LLFA Response Statement

Location: Sunnymeade, Yapton

LLFA Ref:	ADC/ETX4b	Date:	19 th June 2026
Application Number:	Y/24/26/PL	CGS Ref:	C1002

This document provides a formal response to the LLFA comments dated 4th June 2026 relating to the discharge of Y/24/26/PL as part of the planning application referenced above.

flood storage compensation lowering to 2.4 from 3.0
CUT
54m² @ 0.7m 37.8 m³
11m² @ 0.65m 7.1 m³
12m² @ 0.55m 6.6 m³
13m² @ 0.45m 5.8 m³
14m² @ 0.35m 4.9 m³
15m² @ 0.25m 3.7 m³
16m² @ 0.15m 2.4 m³
17m² @ 0.05m 0.8 m³
69.1 m³

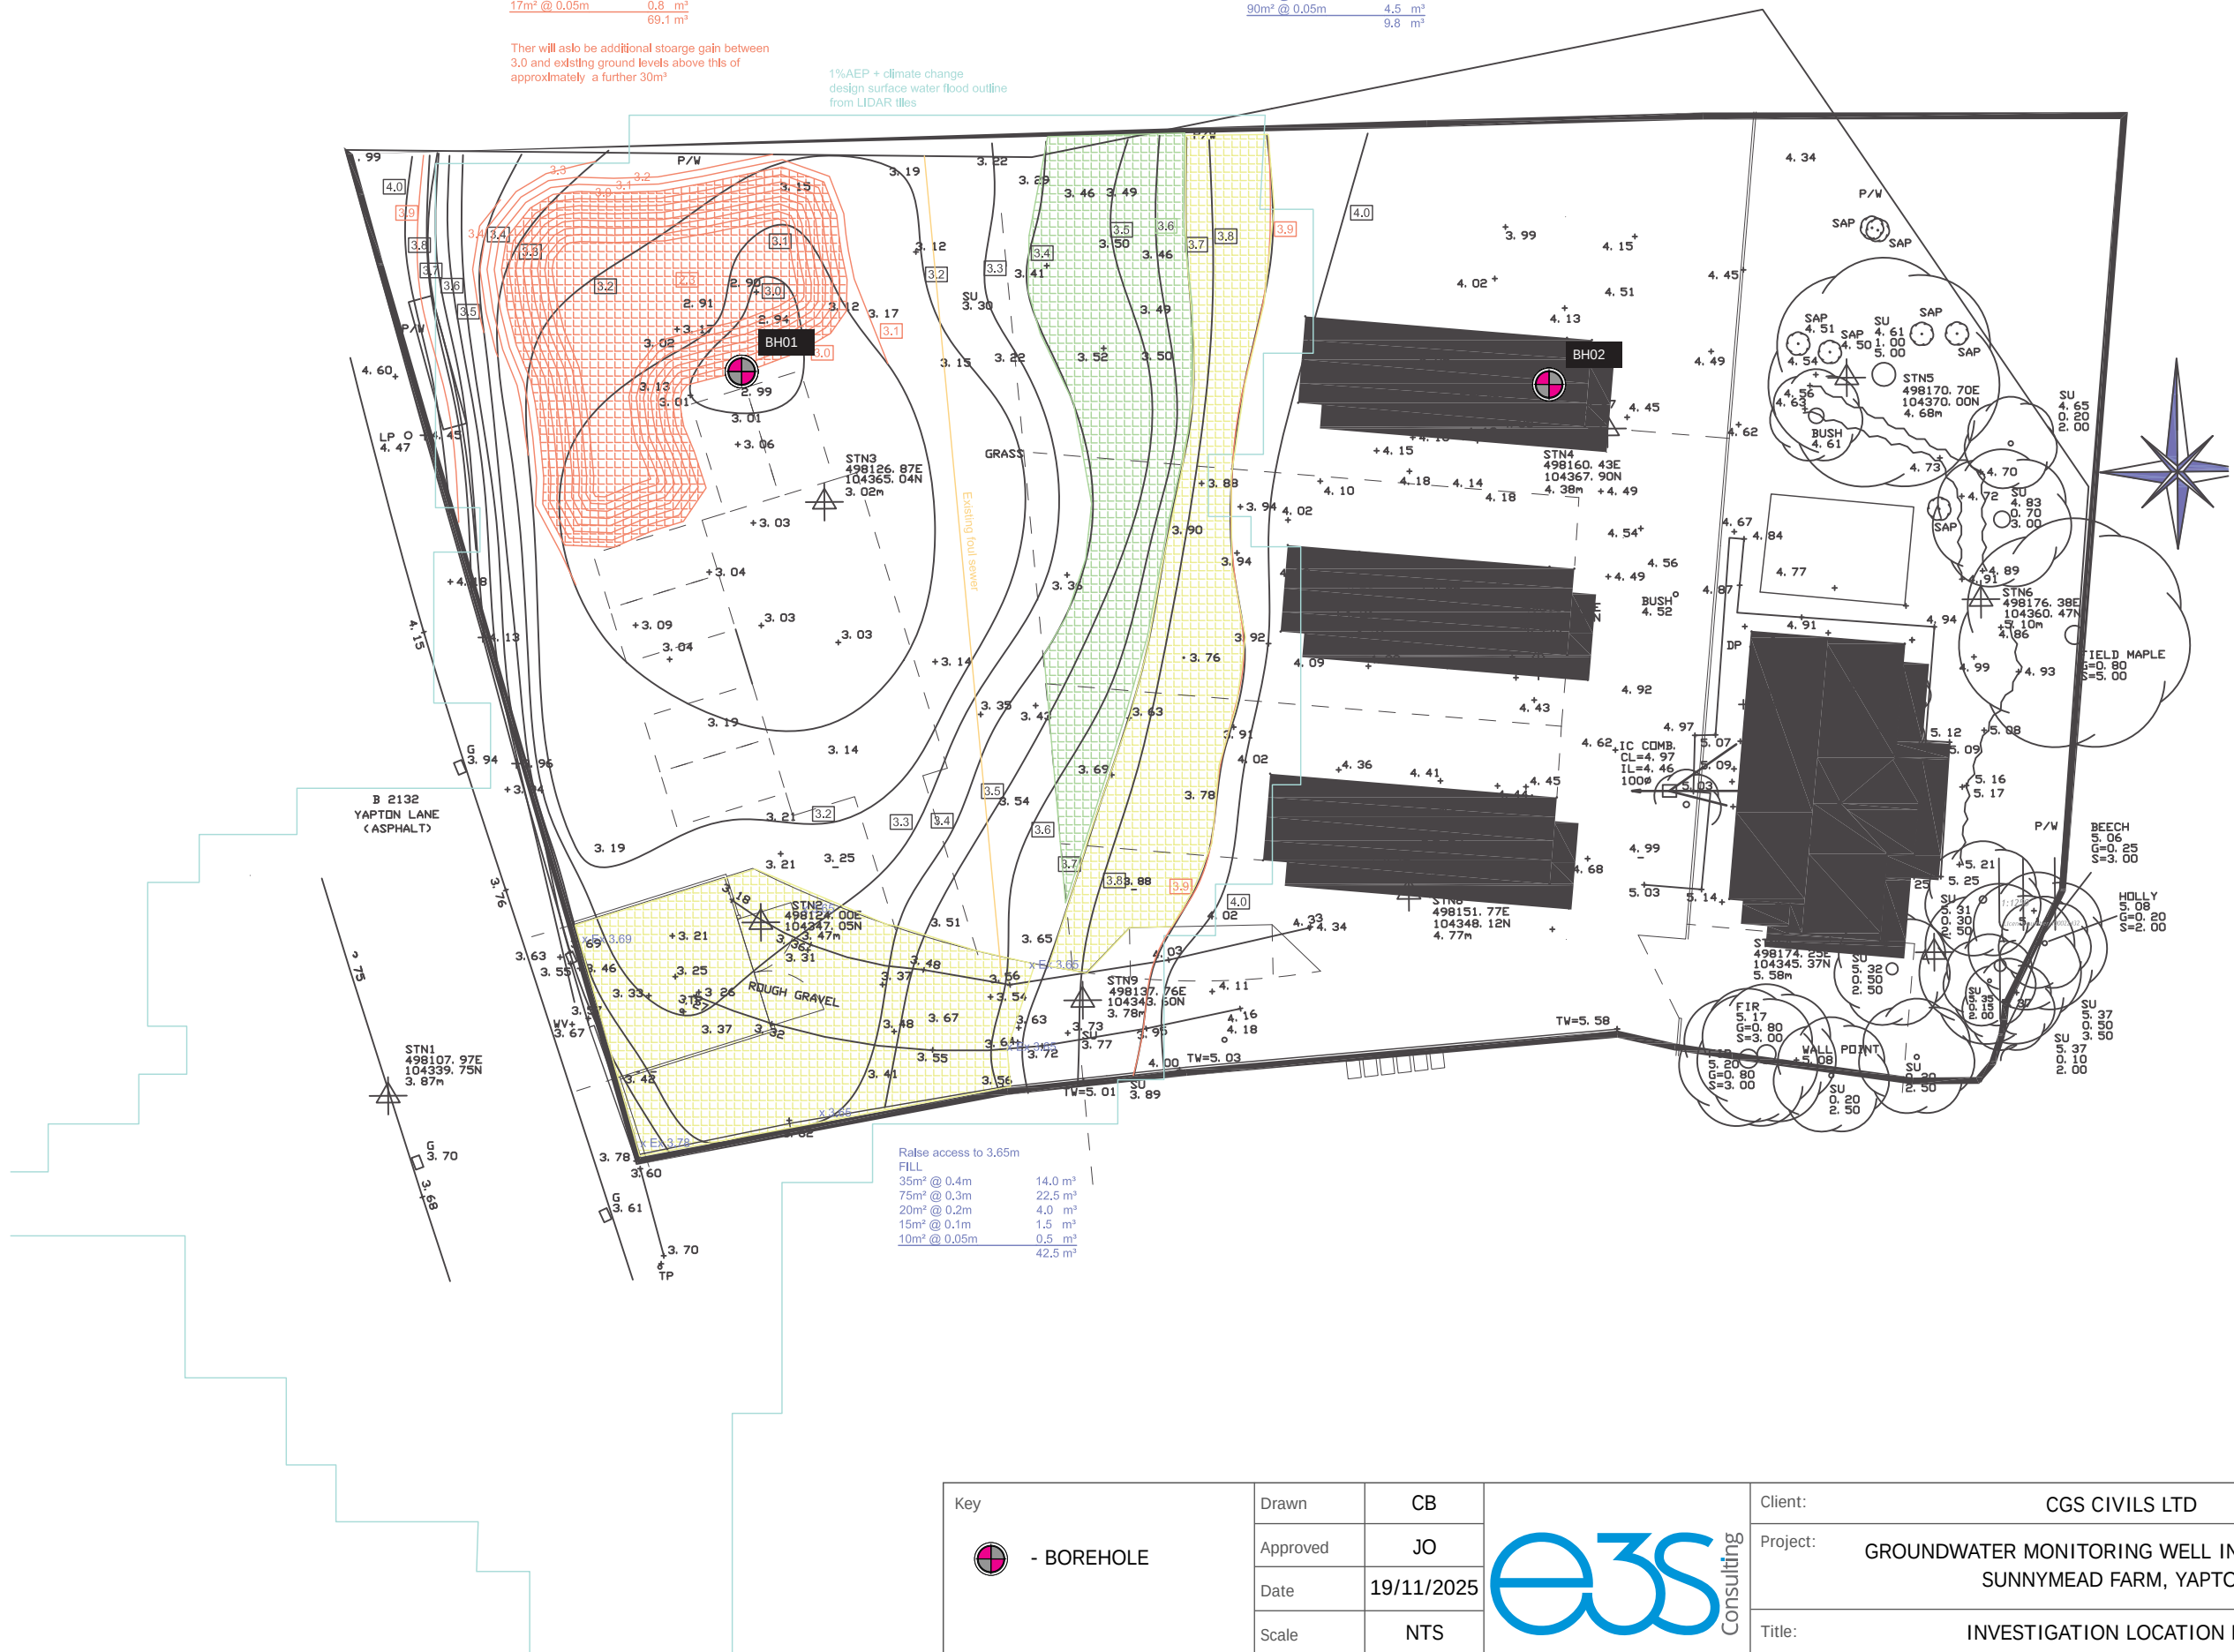
<i>designed with this in mind.” (My emphasis)</i> 3.2. The proposed drainage strategy includes no reference to the surface water flood risk of the site and appears to position all storage features within areas of flood risk, despite parts of the site being at lower risk. By placing storage and infiltrating features in areas of flood risk there is an increased risk that features can be inundated by flood water prior to runoff entering them, rendering them ineffective and thus increasing flood risk. 3.3. Furthermore, the proposed flood storage compensation plan does not follow the level-for-level and volume-for-volume method. As a result, a hydraulic connection between the highway and the applicant land is altered and flood risk will be increased. 3.4. The inadequate consideration of flood risk on the site results in an <u>objection in principle</u> to the application in relation to this standard.	assessment demonstrates that the development does not result in any increase in flood risk on or off site and maintains the required flood storage volume. The proposals therefore demonstrate a net improvement in flood management over the current site arrangement. Flood compensation plans and details indicating level for level and volume for volume flood compensation are included.
